**EL PASO COUNTY PLANNING AND
 COMMUNITY DEVELOPMENT
 DEPARTMENT**

STORMWATER MANAGEMENT PLAN CHECKLIST

Revised: July 2019

EARLY GRADING & EROSION CONTROL PLANS  
 GRANDVIEW RESERVE FILING NO. 1  
 FOR  
 HR GREEN

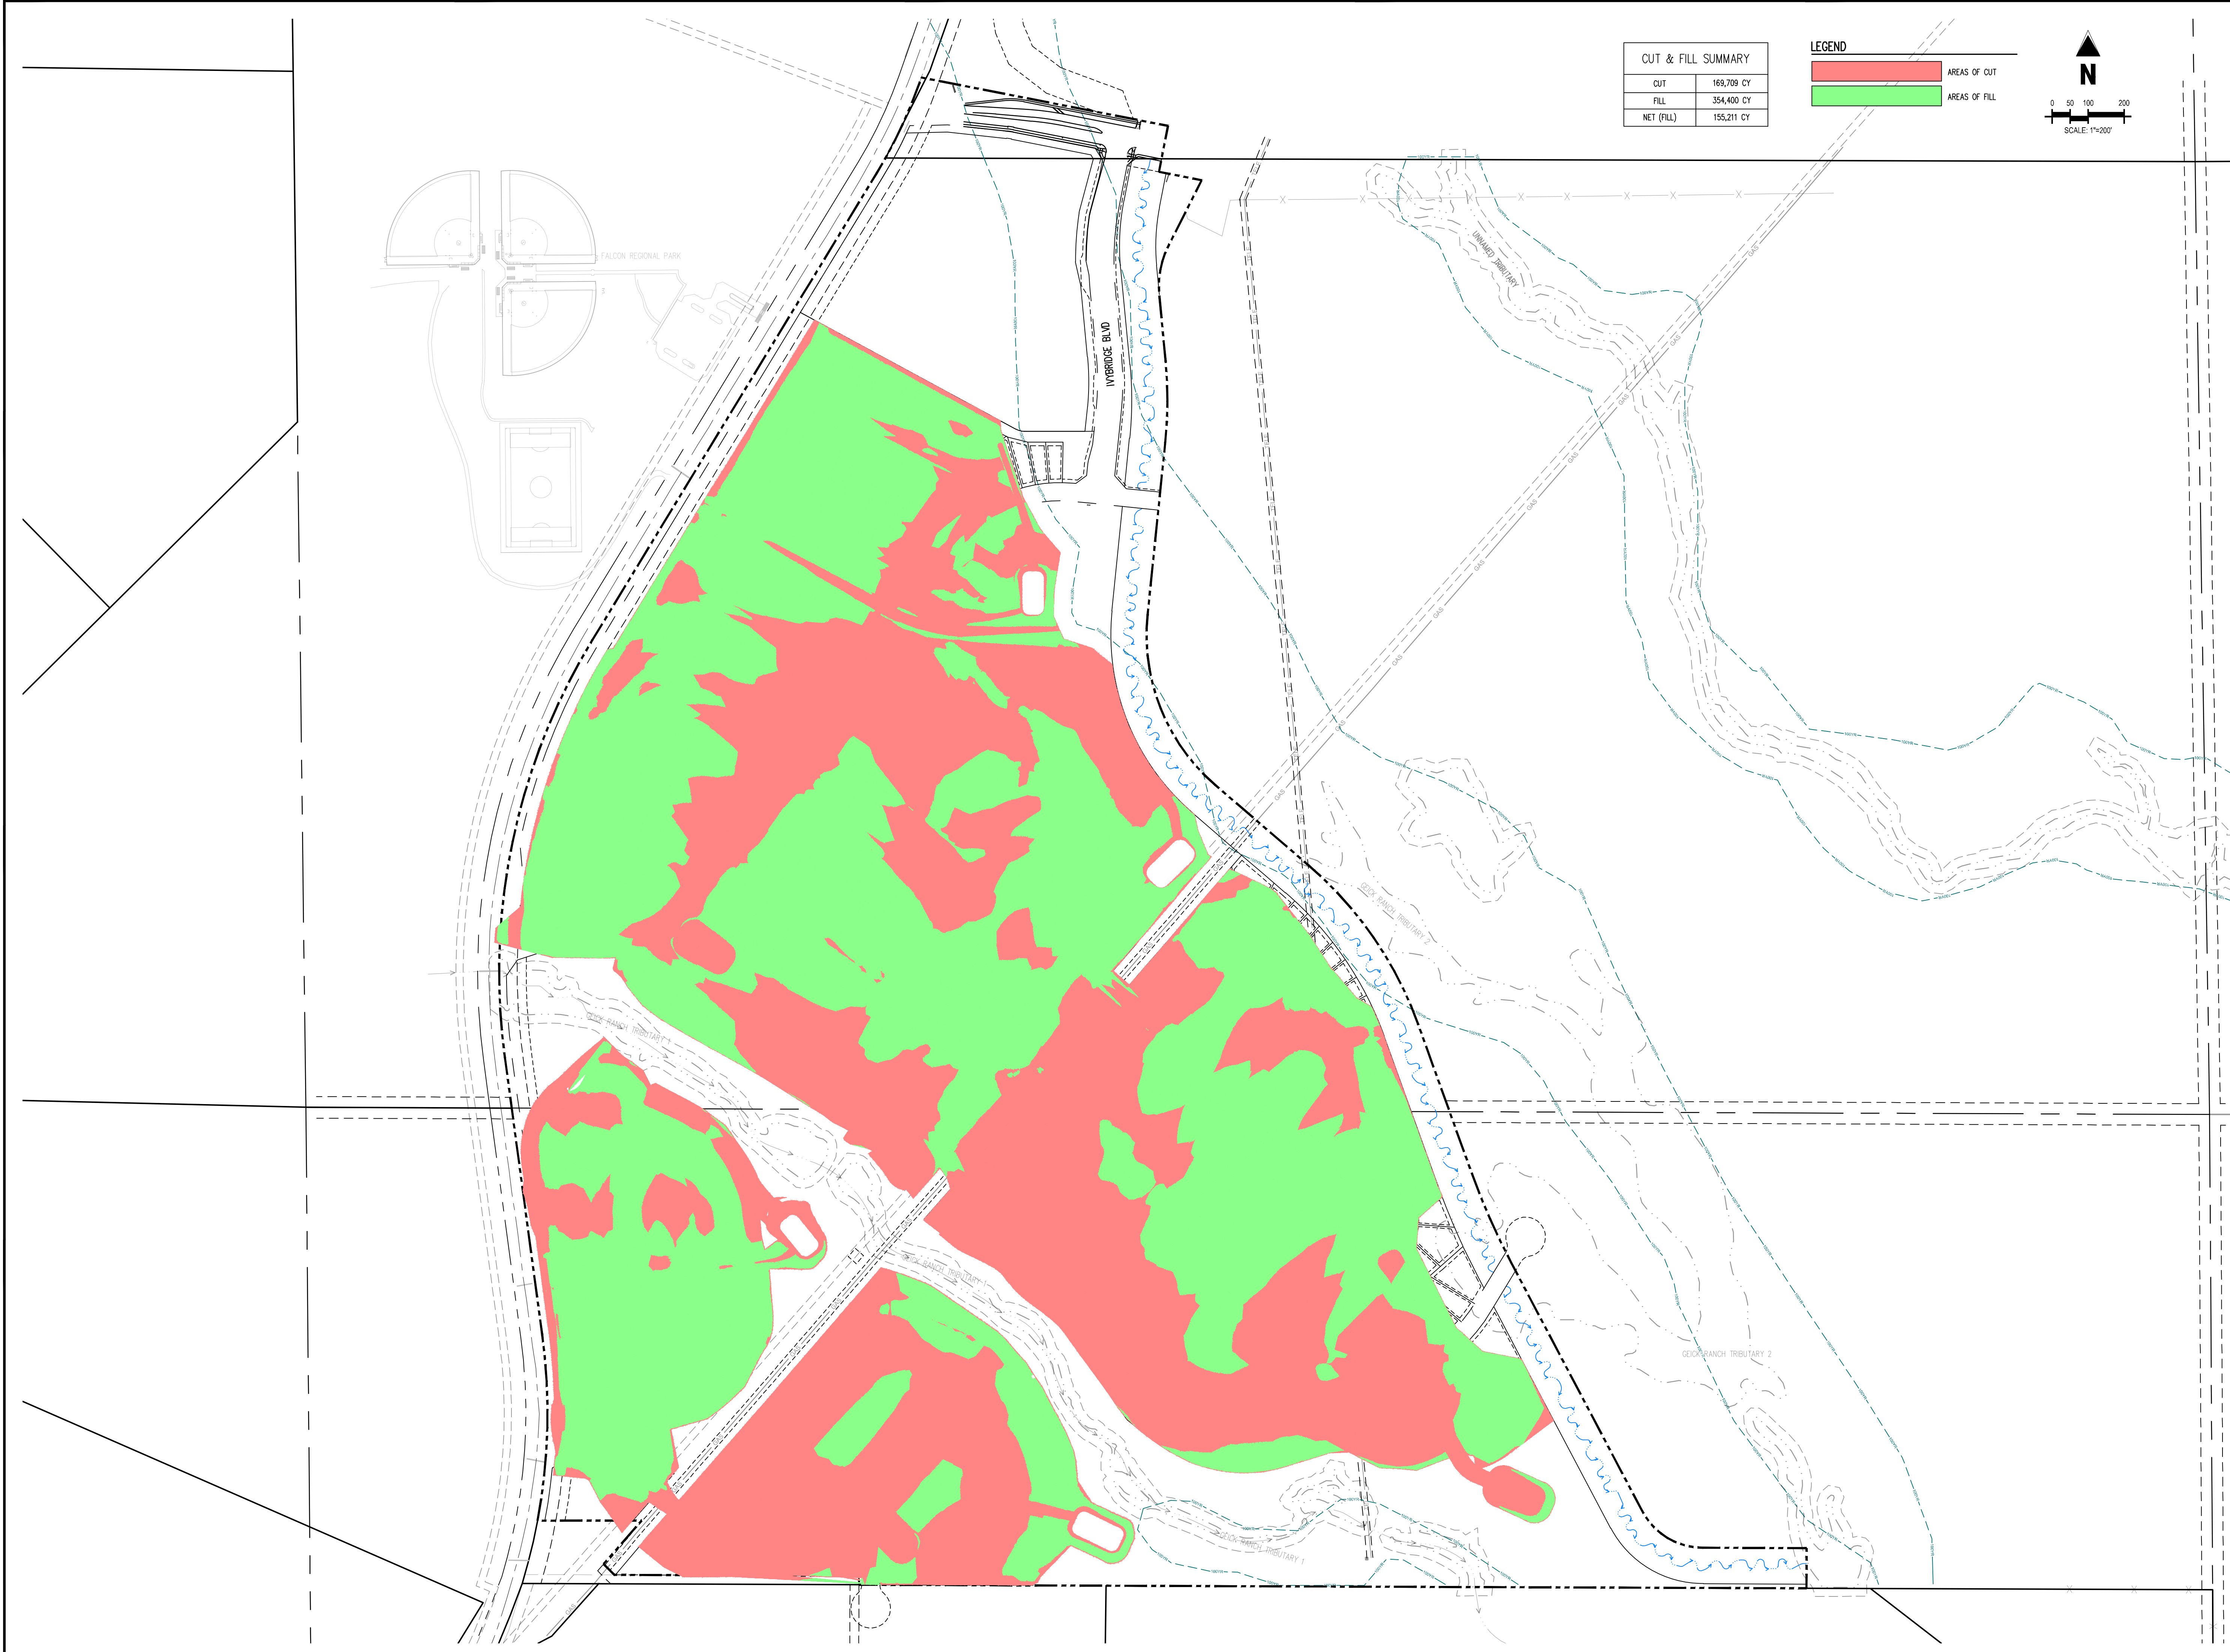
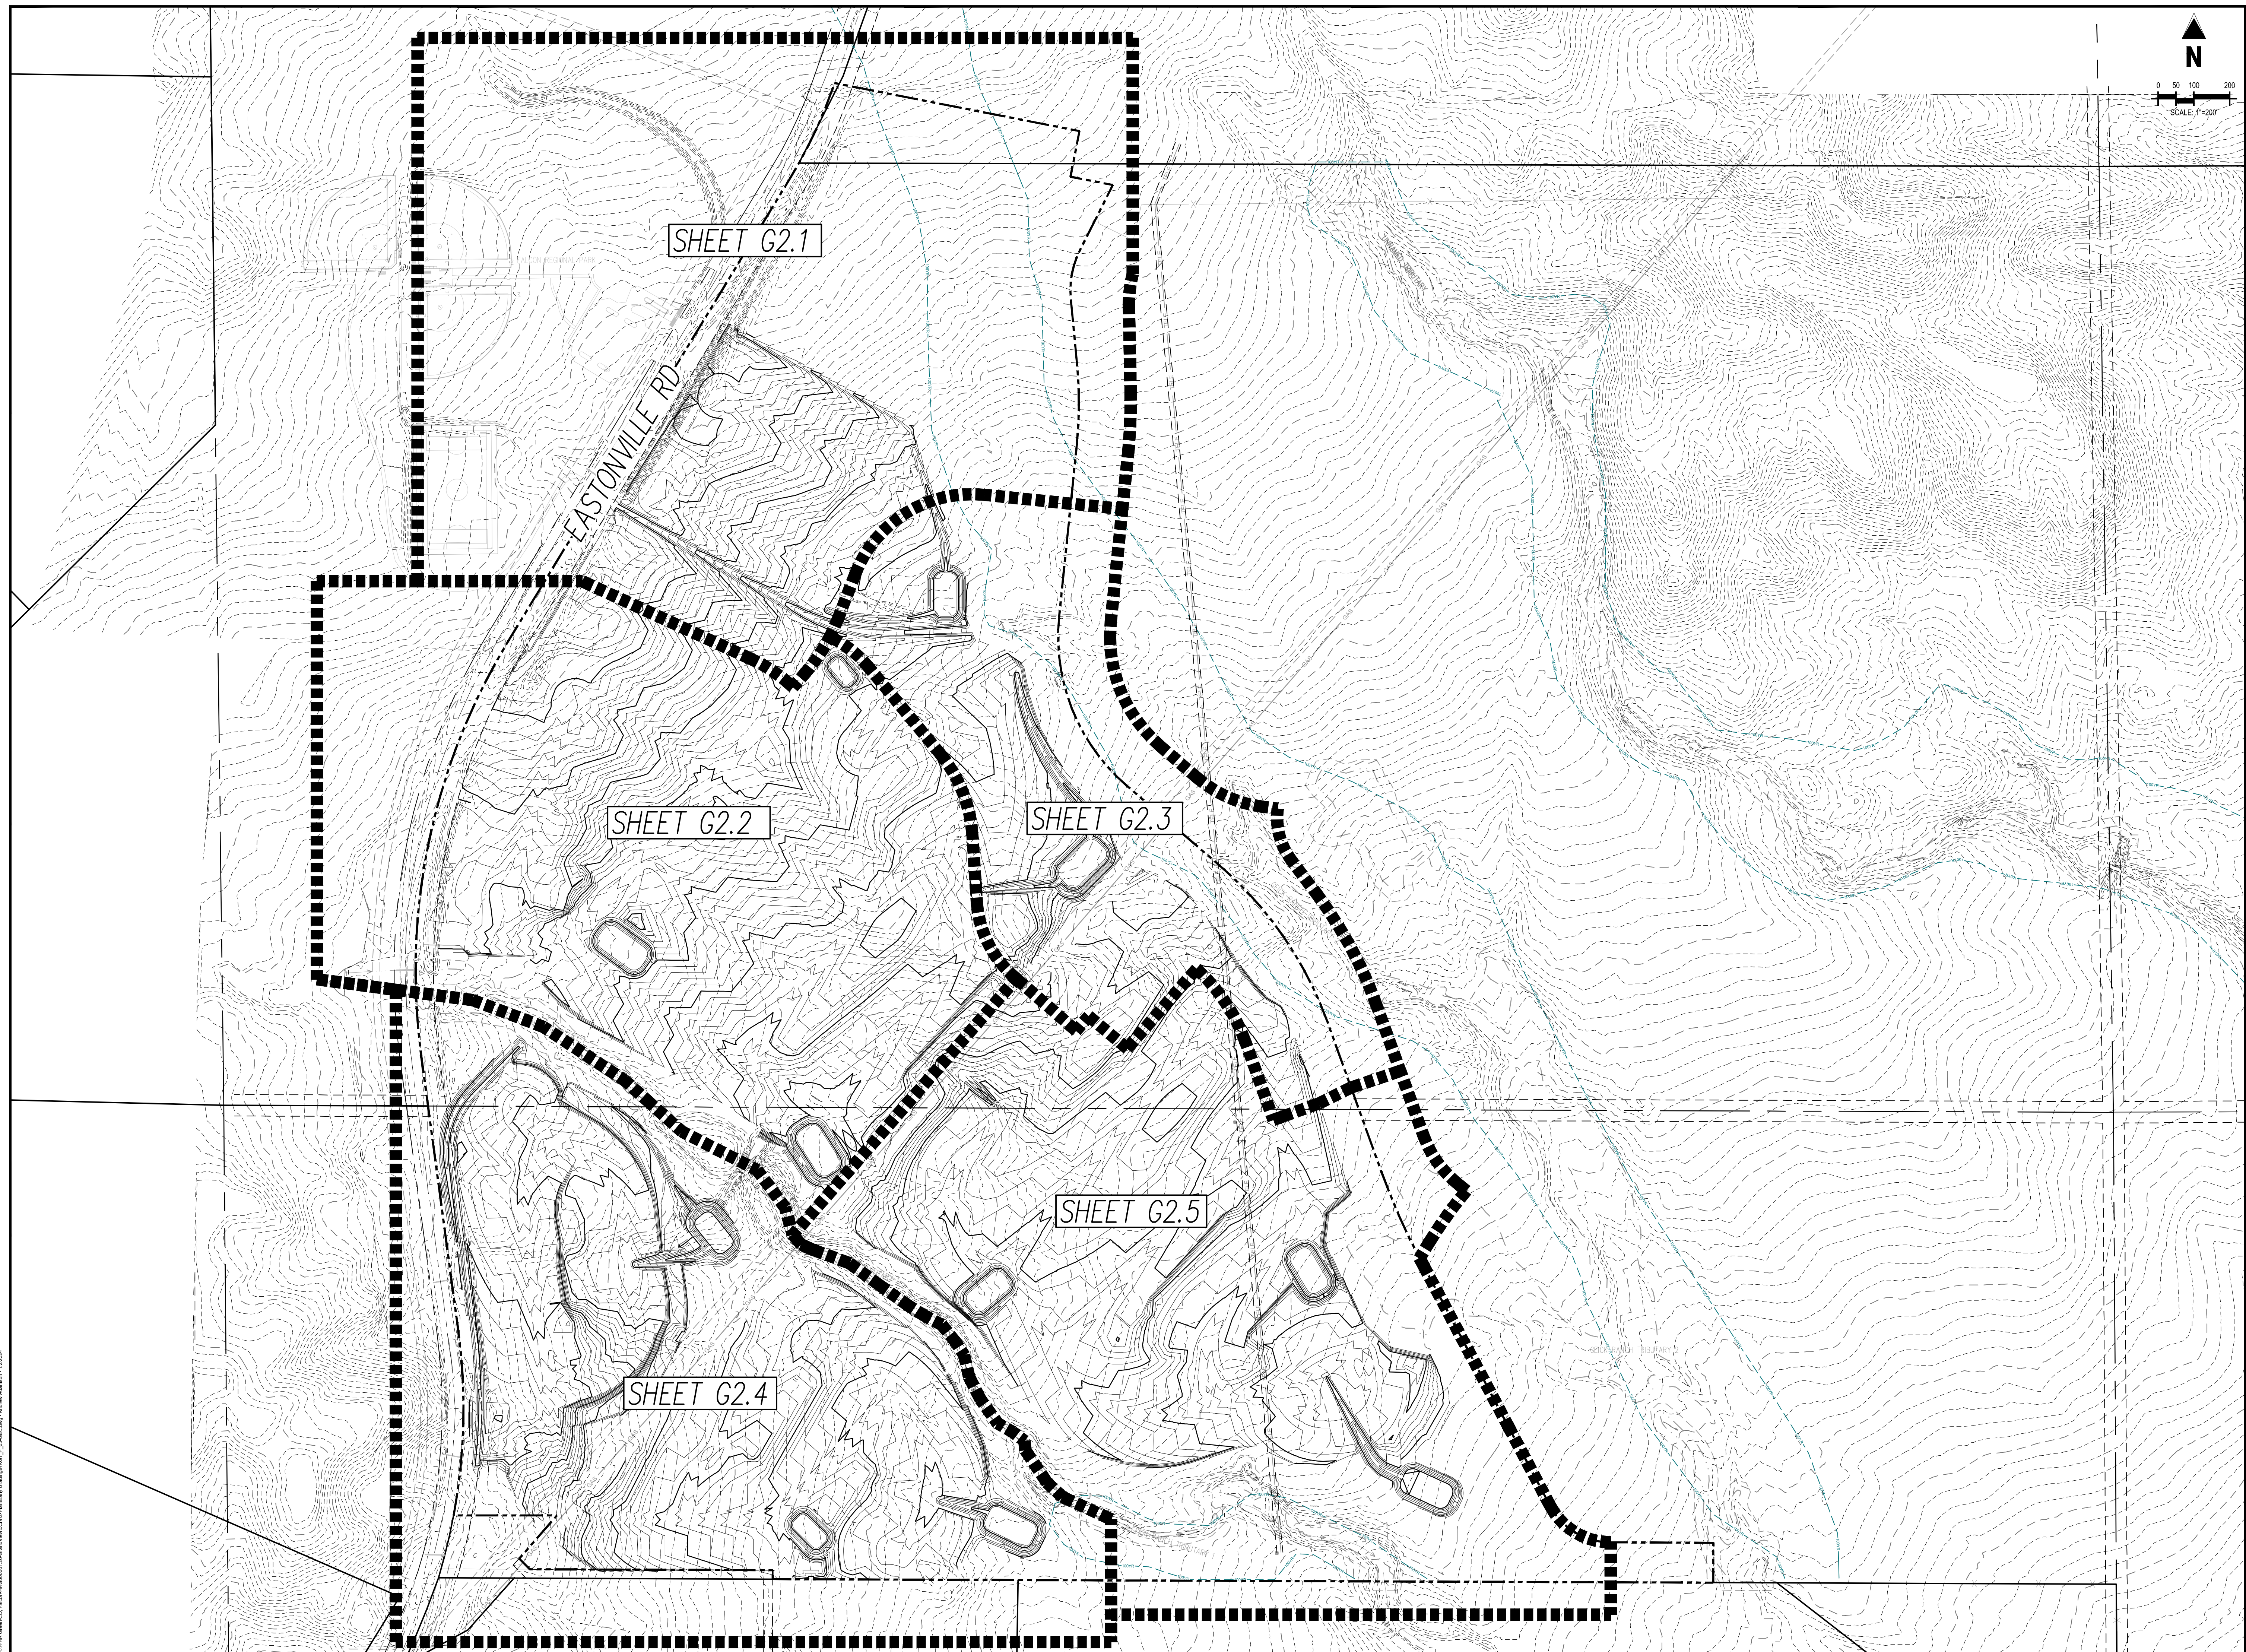
Revised: July 2019		Applicant	PCD
17	SWMP Map to include:	✓	
17a	construction site boundaries	✓	✓
17b	flow arrows to depict stormwater flow directions	✓	✓
17c	all areas of disturbance	✓	✓
17d	areas of cut and fill	✓	X
17e	areas used for storage of building materials, soils (stockpiles) or wastes	✓	✓
17f	location of any dedicated asphalt / concrete batch plants	X	✓
NO DEDICATED BATCH PLANTS PROPOSED			
17g	location of all structural control measures	✓	✓
17h	location of all non-structural control measures	✓	✓
17i	springs, streams, wetlands and other surface waters, including areas that require maintenance of pre-existing vegetation within 50 feet of a receiving water	✓	✓
18	Narrative description of all structural control measures to be used. Modifications to EPC standard control measures must meet or exceed County-approved details.	✓	✓
19	Description of all non-structural control measures to be used including seeding, mulching, protection of existing vegetation, site watering, sod placement, etc.	✓	✓
